ROZELLE VILLAGE DEVELOPMENT

ACCESS REVIEW

Morris Goding Accessibility Consulting

15th February 2012

LEVEL GROUND PLAN
 RL 39.57

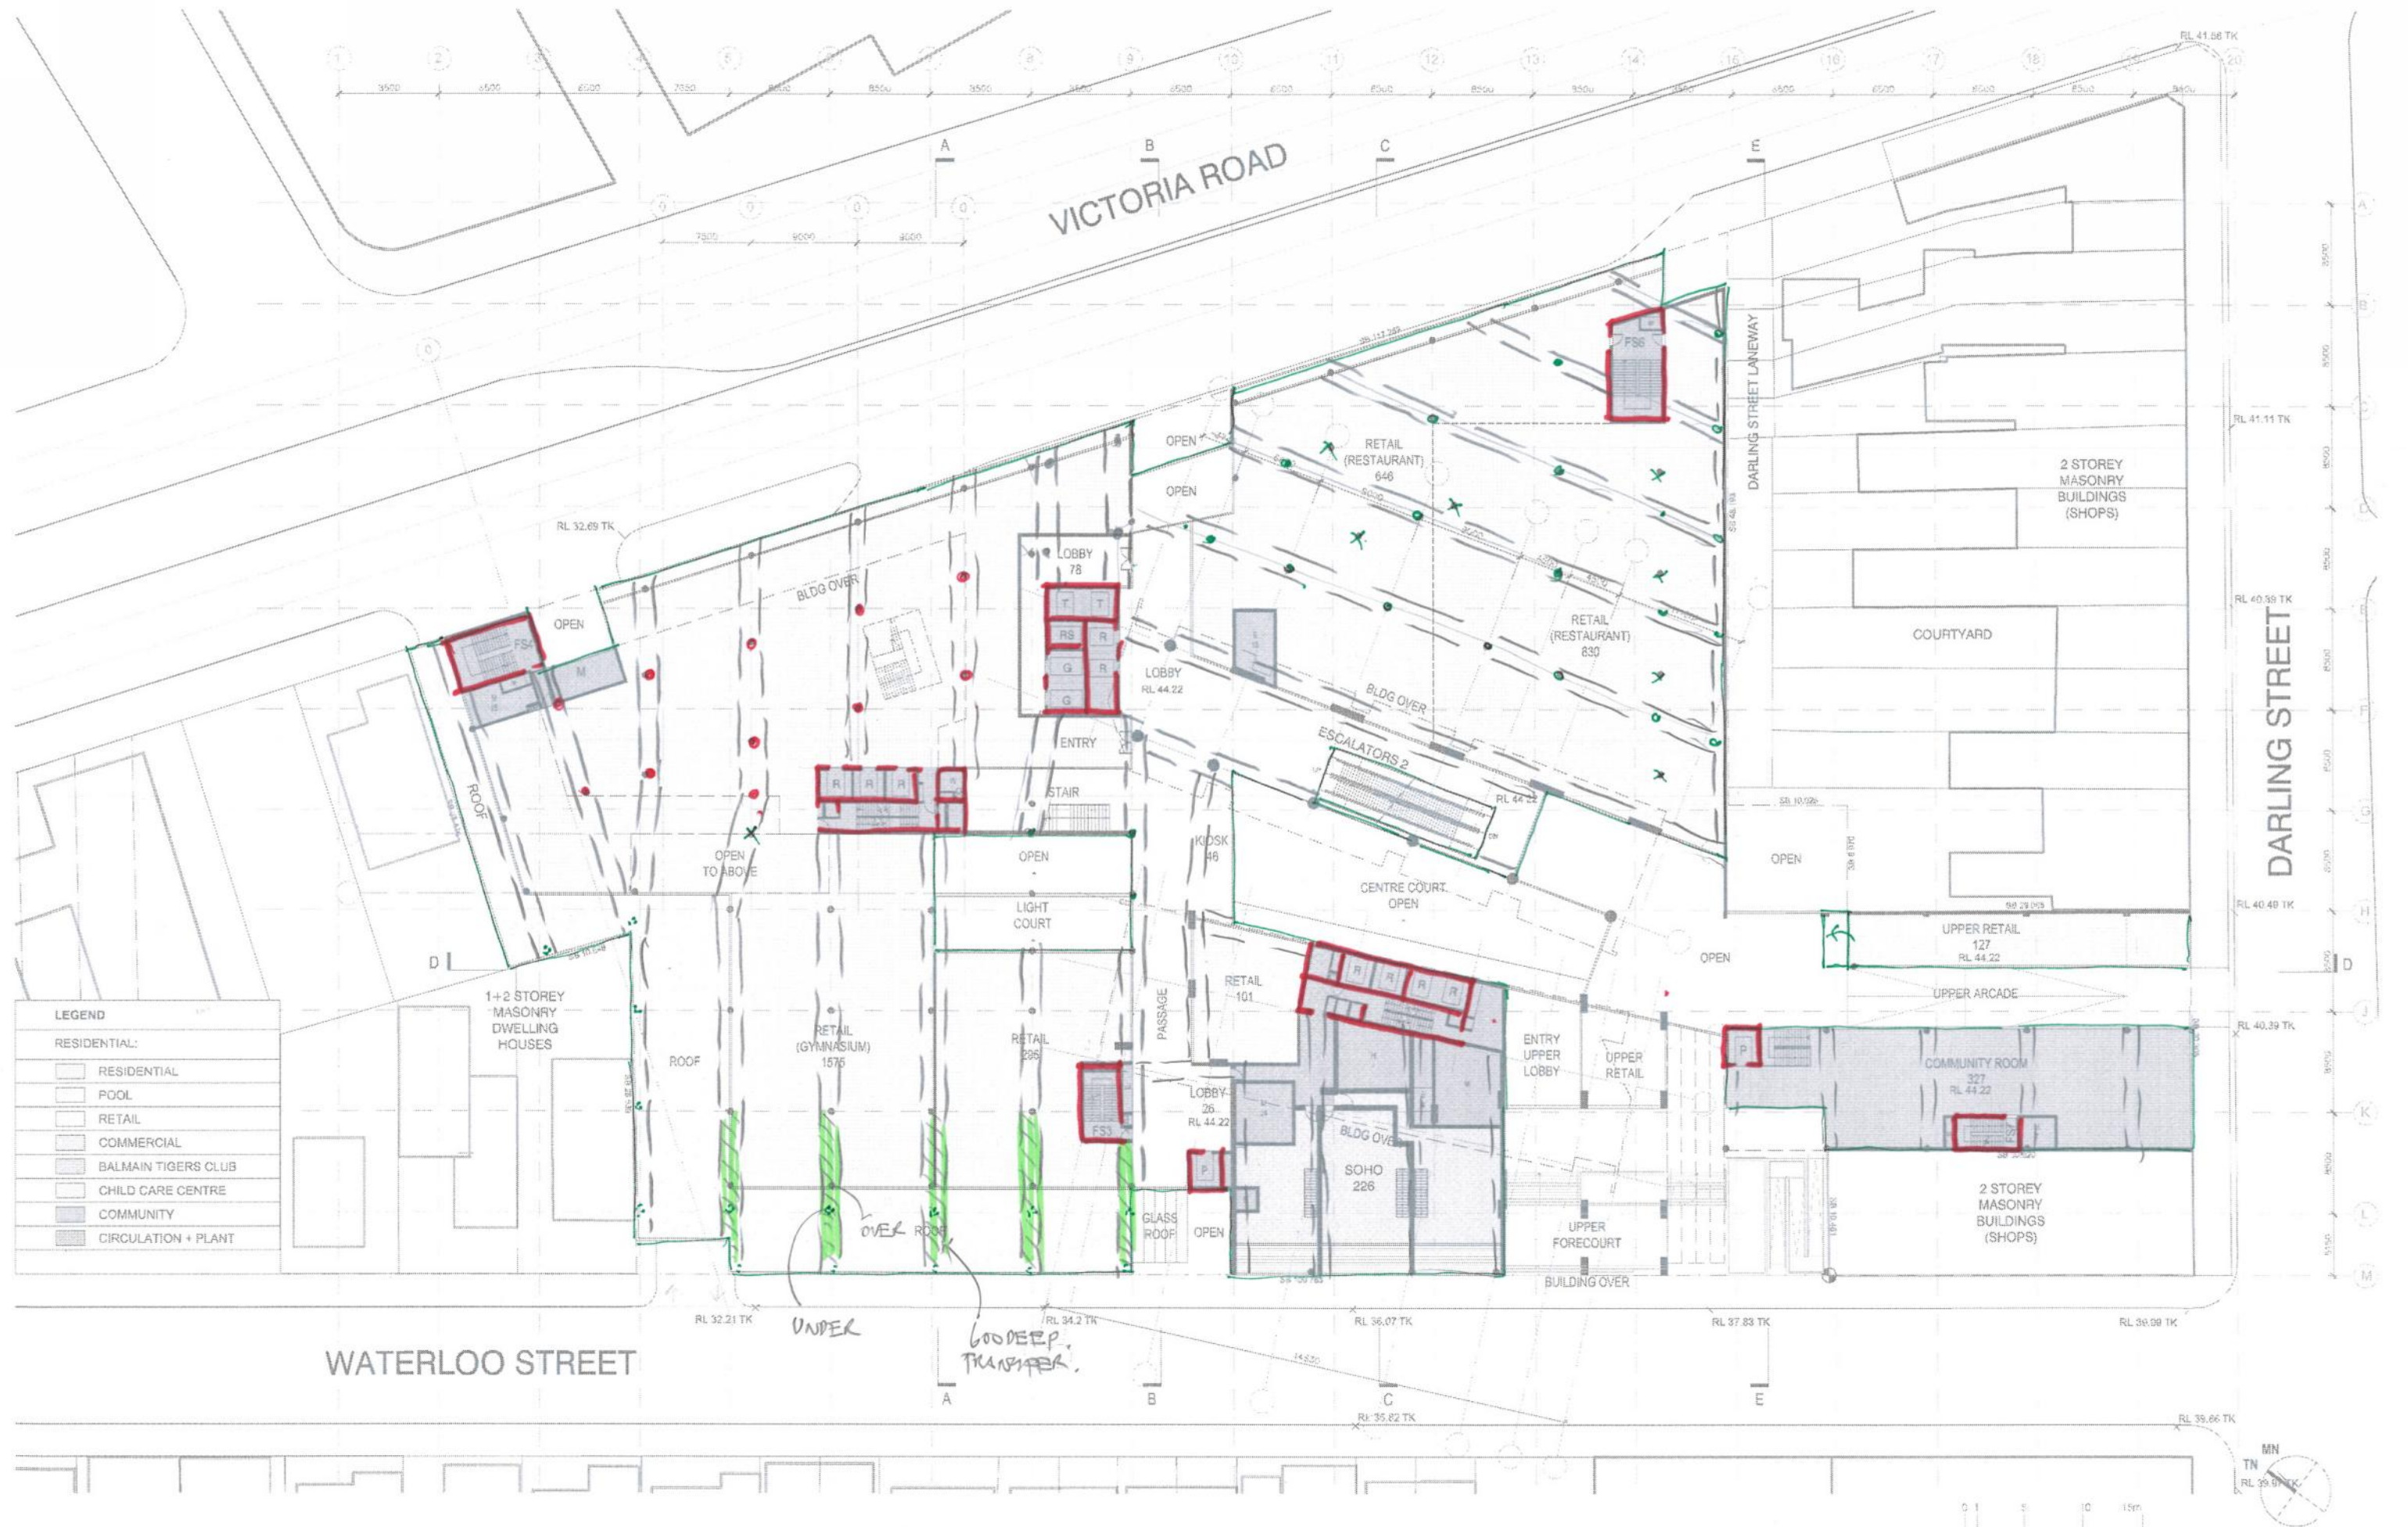
There are three entrances into the development from Waterloo Street. At basement 1 level (RL 35.25) there is stair 1 (RL 34.80) with an adjacent lift providing continuous access to Retail Lobby. At ground level (RL 38.00) there are tapered entry stairs leading to Forecourt stairs 2 and 3 into the development. There is also a turn-back ramp access located within 50m of these stair entrances, compliant with the DDA Premises Standards. The Waterloo Street ramp will ensure an accessible path of travel from the pedestrian footpath for a person using a wheelchair into the development.

The gradient of the ramp appears to be 1:14. The ramp has a suitable 1200mm width and maximum length of 9m between landings compliant with AS1428.1. Mid-landings appear to have 1000mm length need to be modified to comply with AS1428.1. This is achievable.

- (i) Ensure Waterloo Street entry ramp has mid-landings with minimum 1540mm depth suitable for 180° wheelchair turns, compliant with AS1428.1.
- (ii) Ensure Waterloo Street entry stairs and ramp has handrails installed on both sides, compliant with AS1428.1. The tapered entry stairs need to be recessed from site boundary to allow for handrails to be installed in compliance with AS1428.1.

<p>LEVEL 1 PLAN RL 44.22</p>						<p>PA 111 14</p>

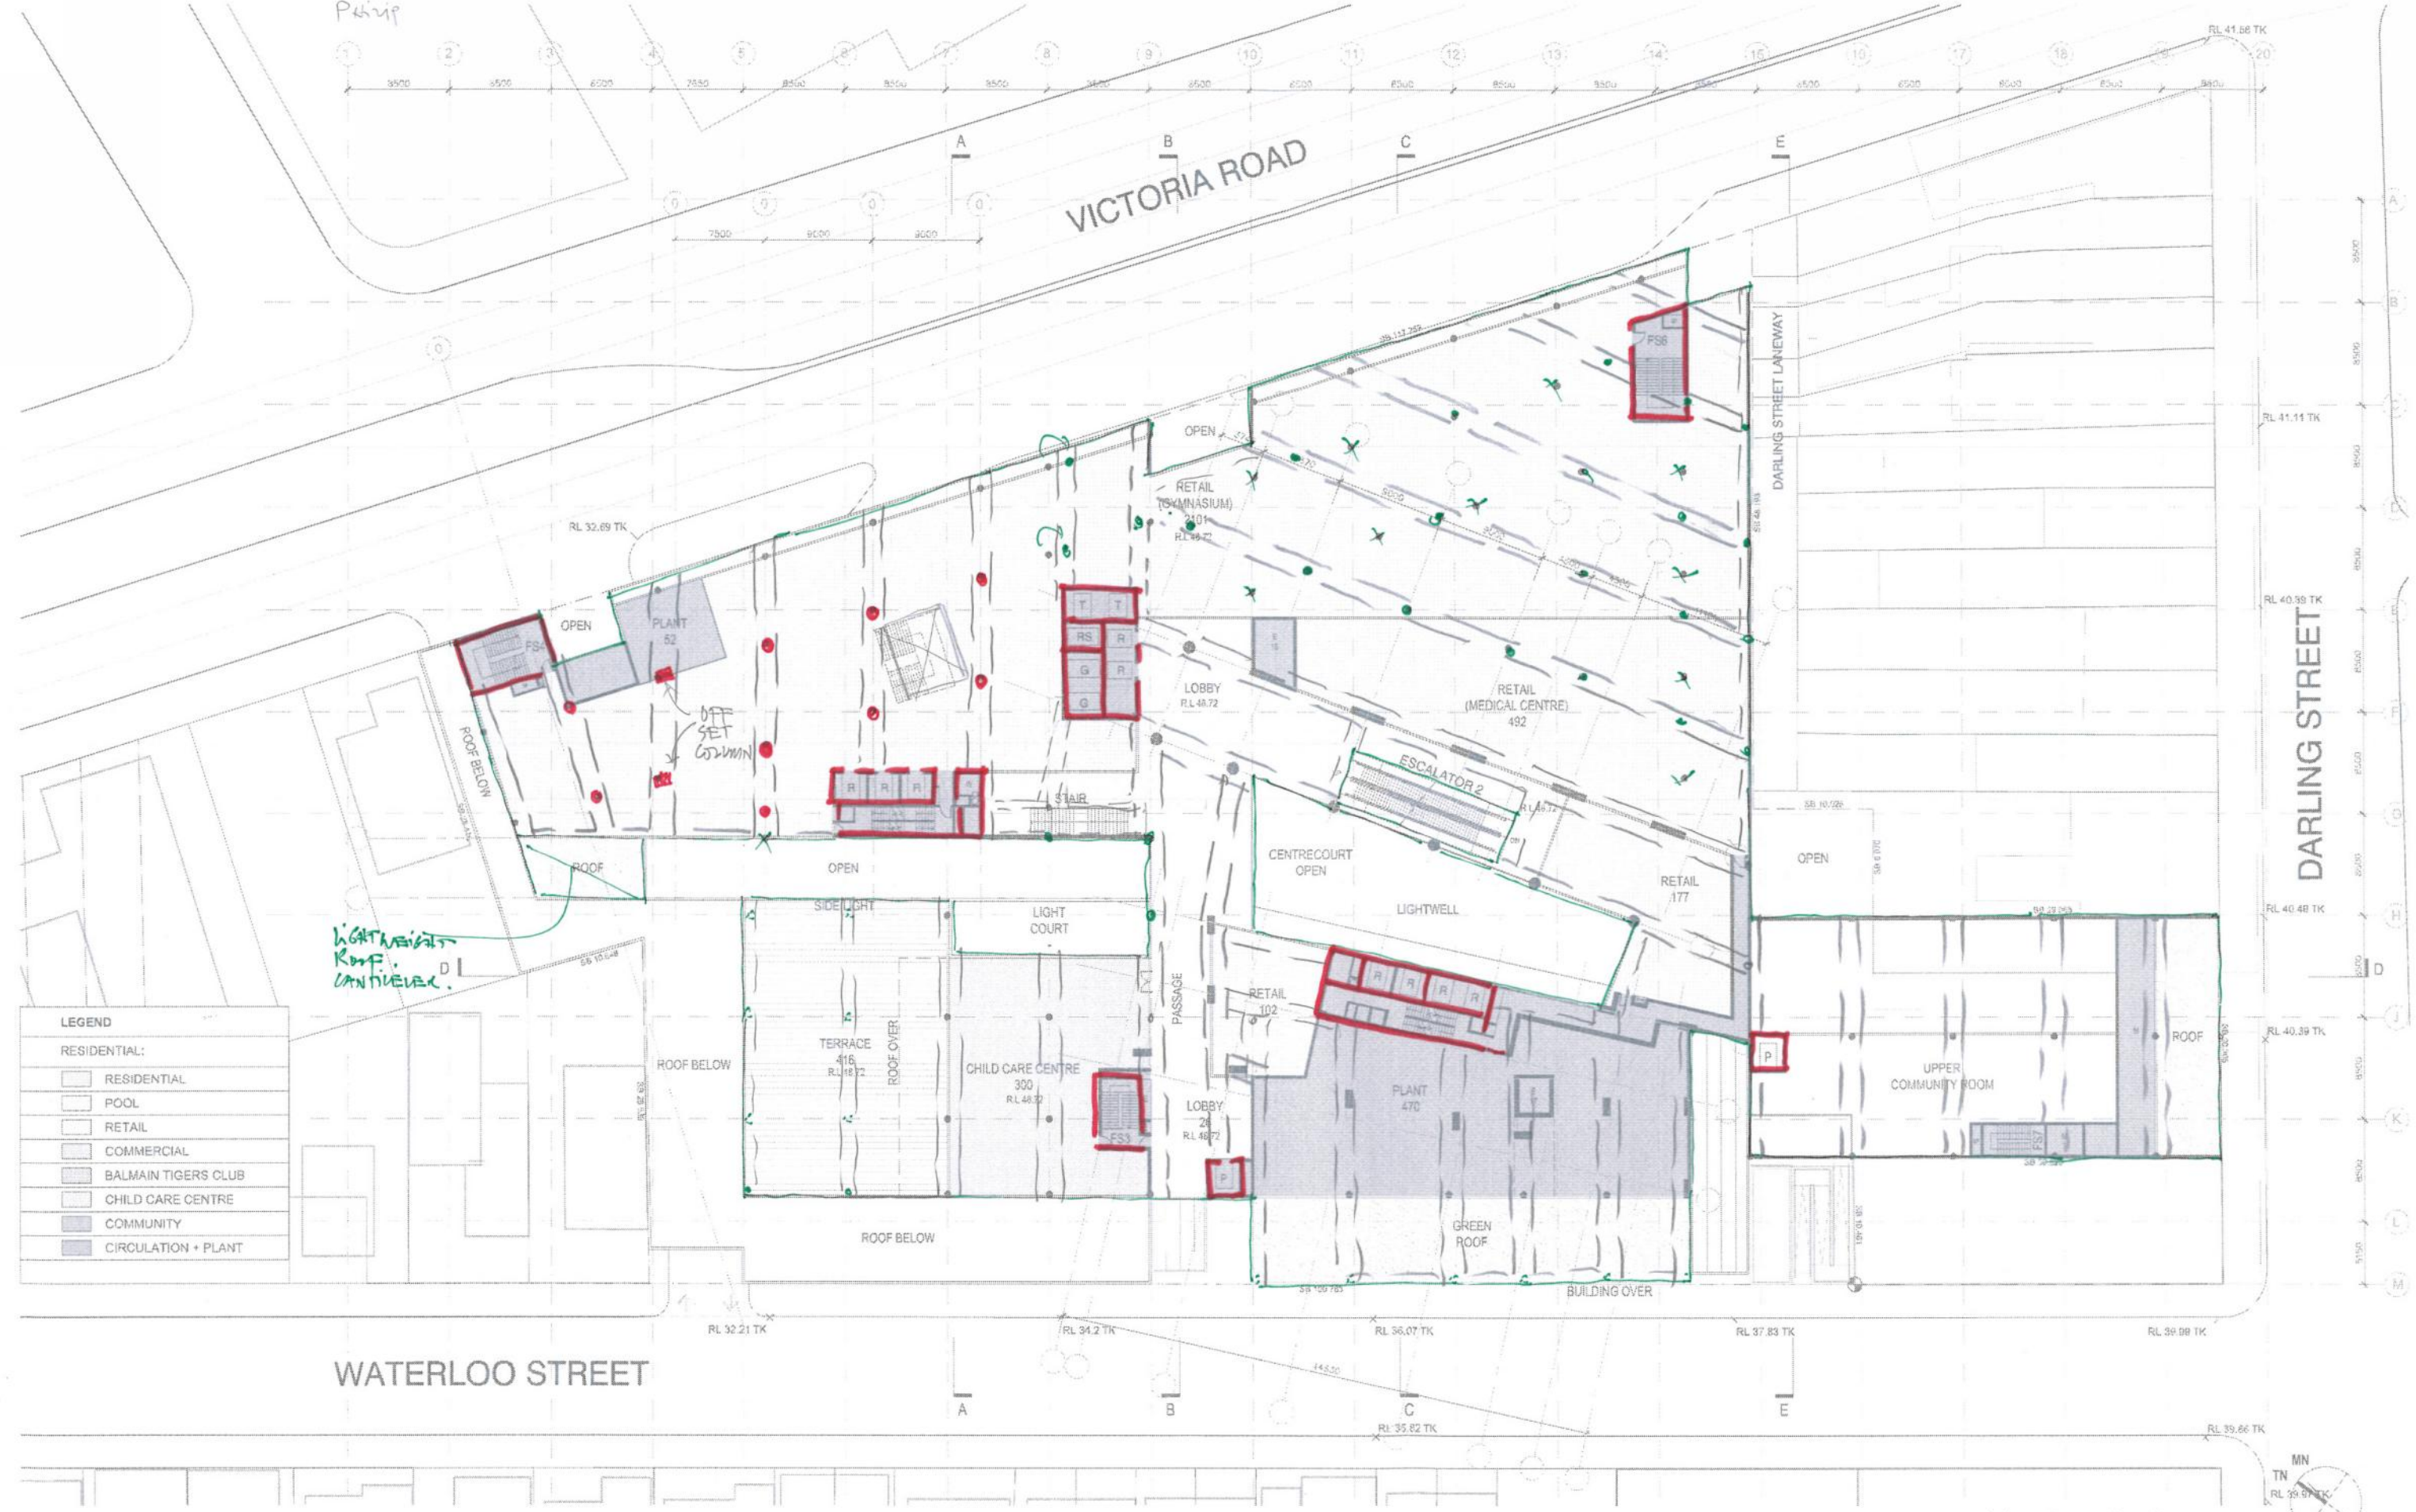
There is a gymnasium located on level 1 and 2 of the development. Entry is shown at level 1 from the Retail Lobby which has suitable lift access from the ground level entrances. The dual hinged entry doors location (near column) requires review to ensure suitable 850mm clear width active leaf and door circulation, compliant with AS1428.1. This is achievable.

There are communication stairs shown within the tenancy between the level 1 and 2 gym areas. The design is capable of accommodating an alternative lift access as required by the DDA Premises Standards to ensure equity for people using wheelchairs who wish to use both levels of the gym.

- (i) Ensure an alternative accessible linkage (ie. passenger lift) to the level 2 gym area from level 1 gym area in accordance with the DDA Premises Standards. We understand that this linkage will be provided by third parties and through an additional development application.
- (ii) Ensure the internal communication stair between gym levels have handrails installed on both sides, compliant with AS1428.1.
